Our Ref: BR/241/19/HH
Your Ref:

Town & Country Planning Act 1990 (as amended)
Town & Country Planning (Development Management Procedure) (England) Order 2015
Application for Planning Permission for Works or Extension to a Dwelling

Development Side extension to replace garage conversion.

Location 12 Stratton Court Bognor Regis

Block Plan shows area bounded by: 494258.03, 100075.96 494348.03, 100165.96 (at a scale of 1:500), OSGridRef: SU9430 12. The representation of a road, track or path is no evidence of a right of way. The representation of features as lines is no evidence of a property boundary.

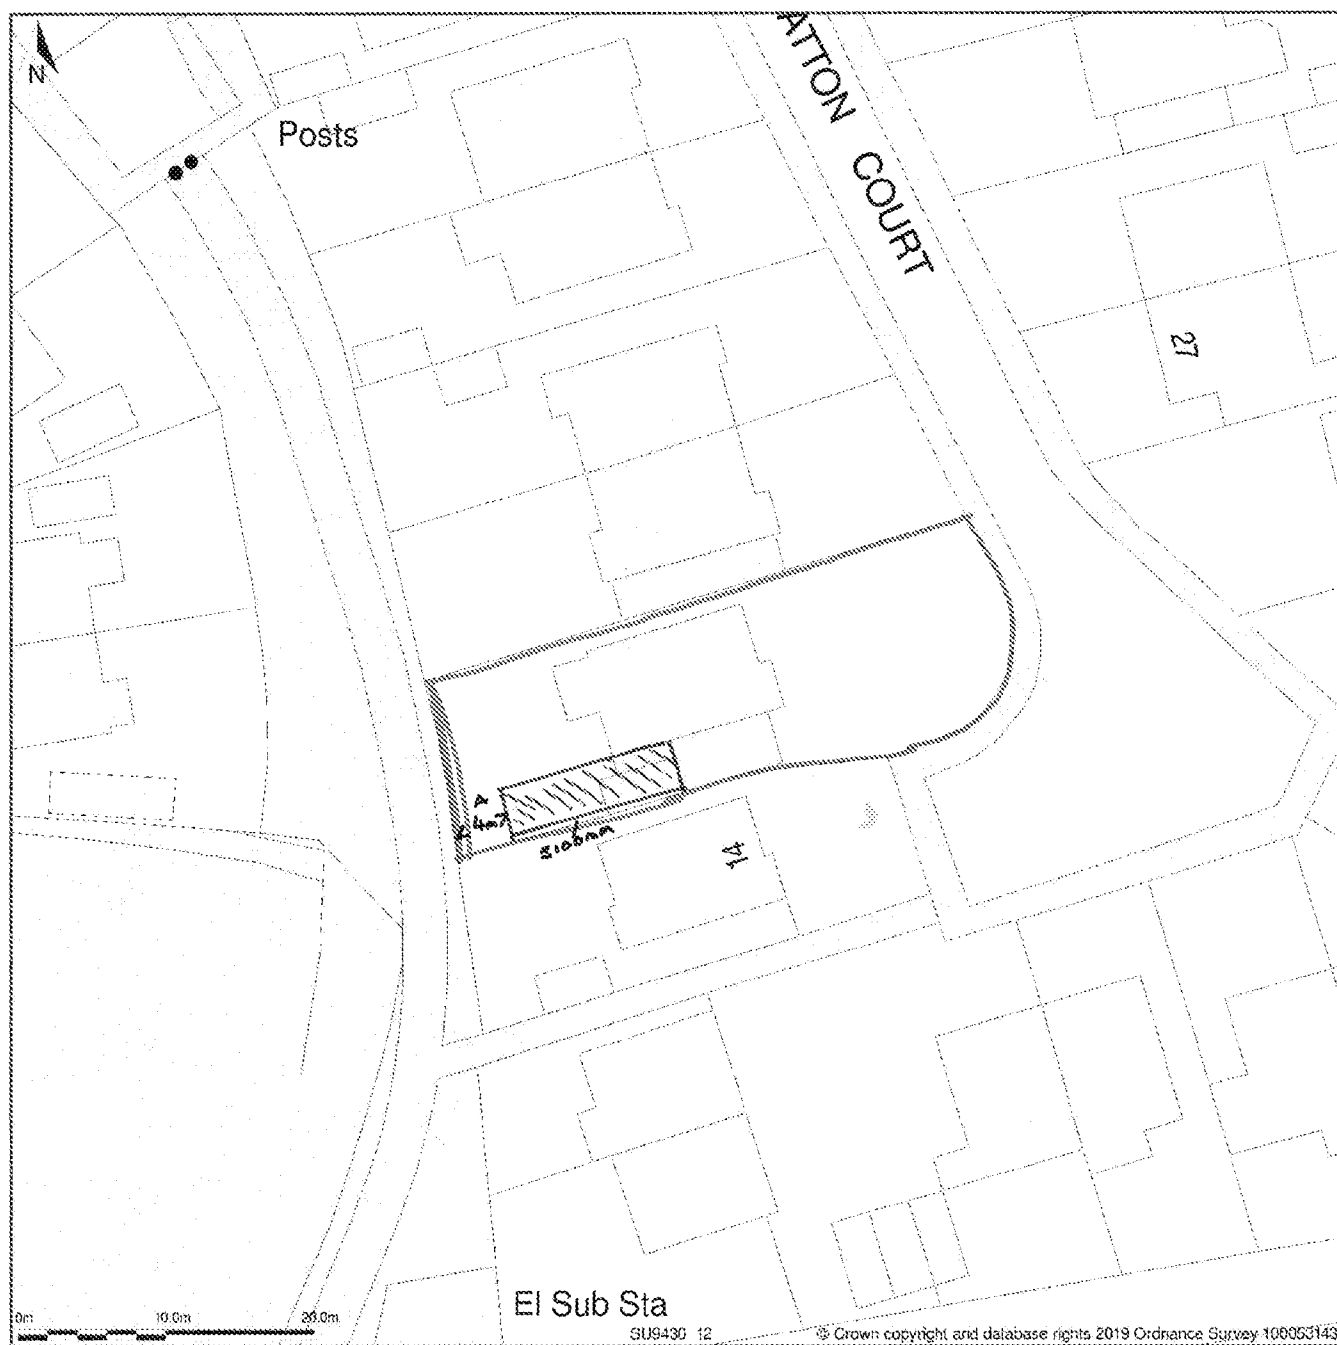
Please amend the block plan to include dimensions to boundaries.

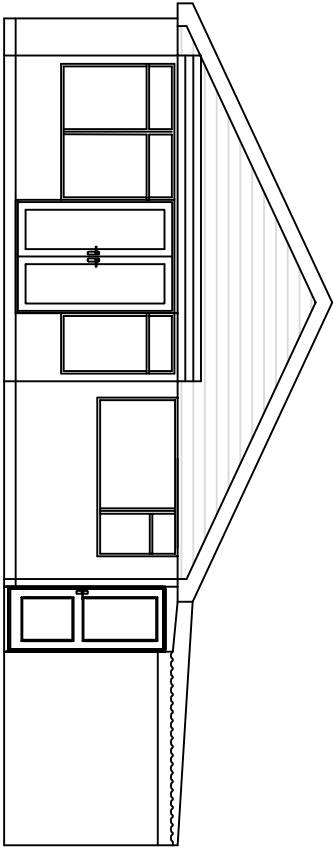
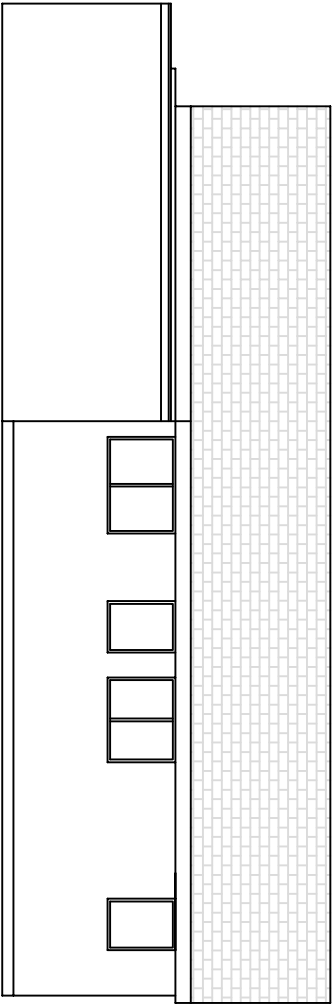
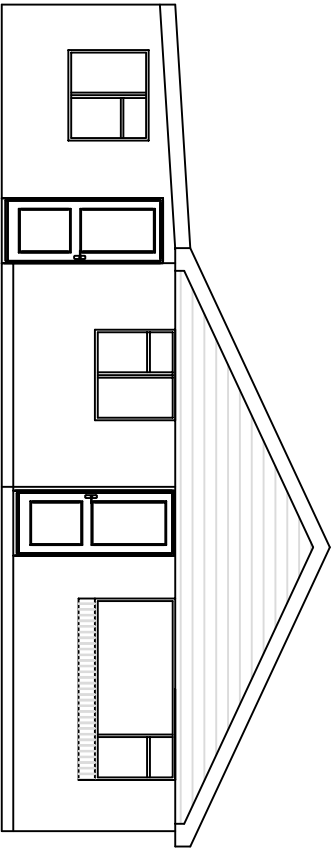
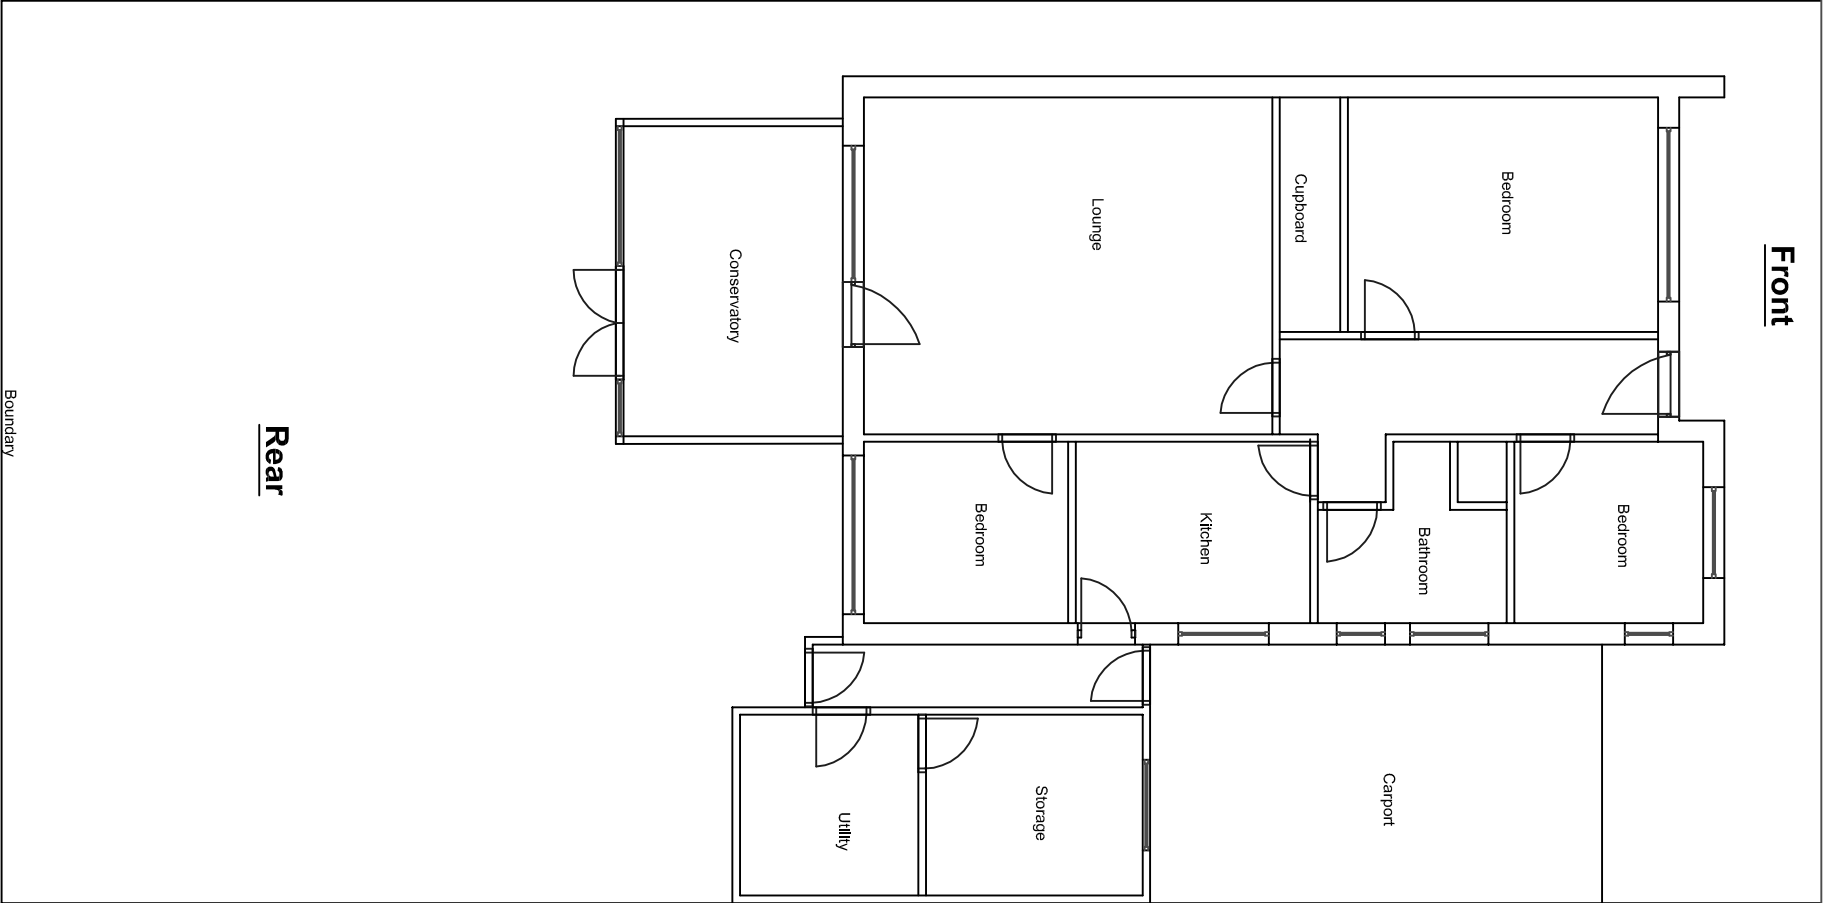
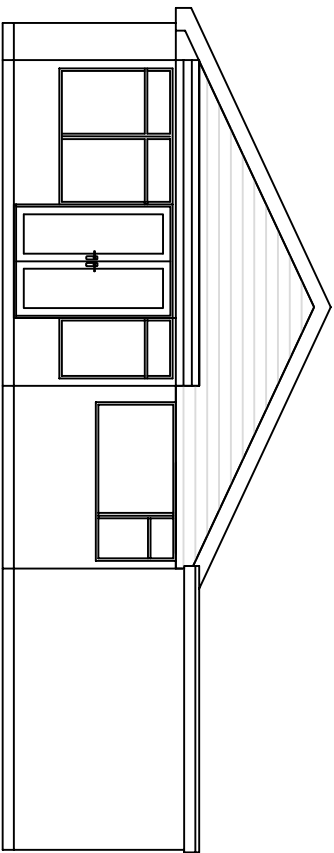
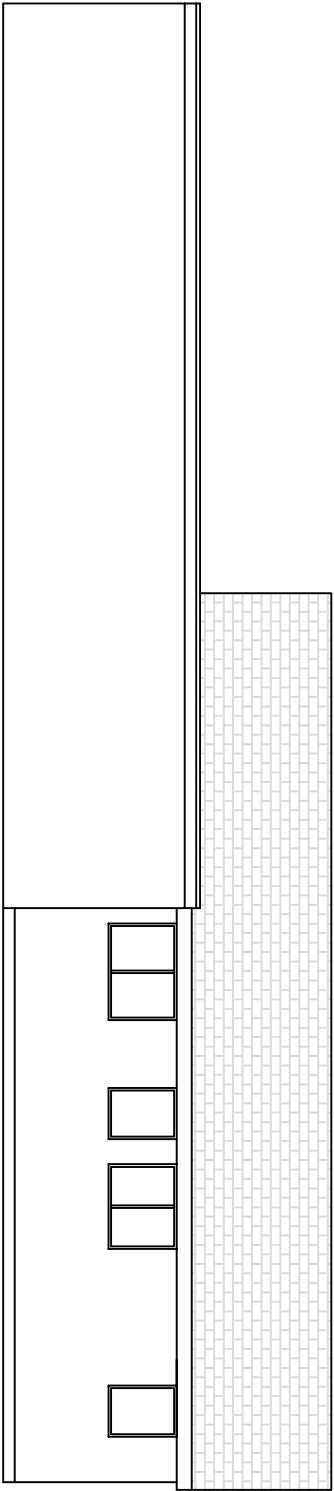
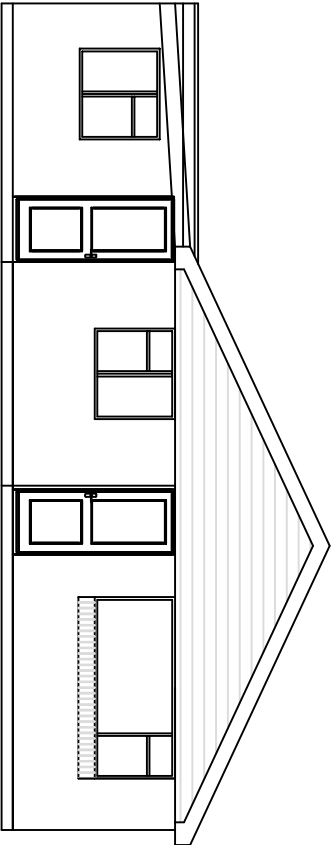
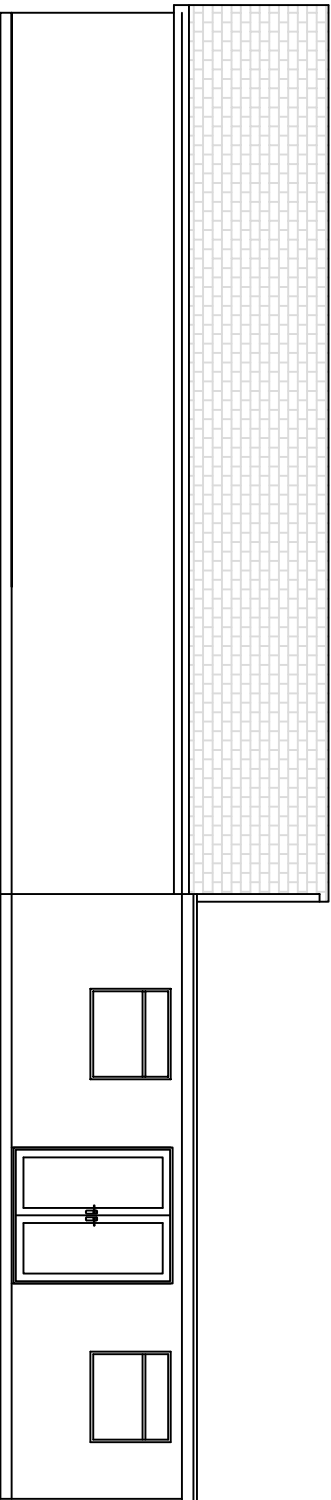
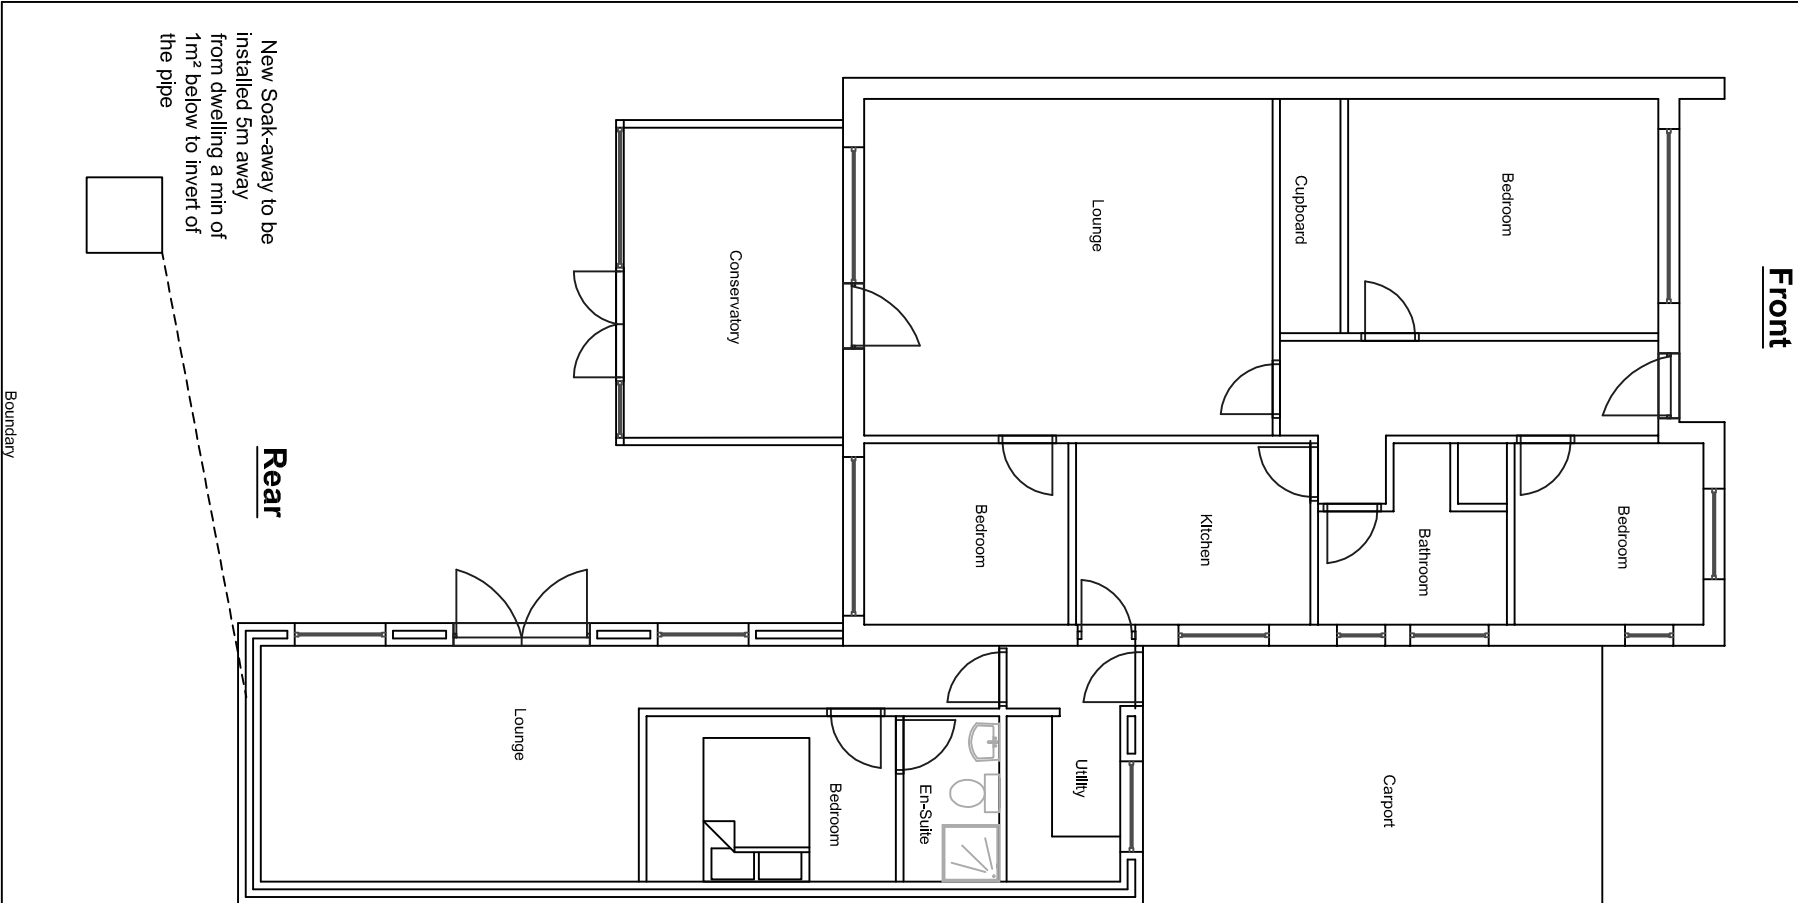
The existing and proposed elevations do not accord. Please amend to show all windows and doors.
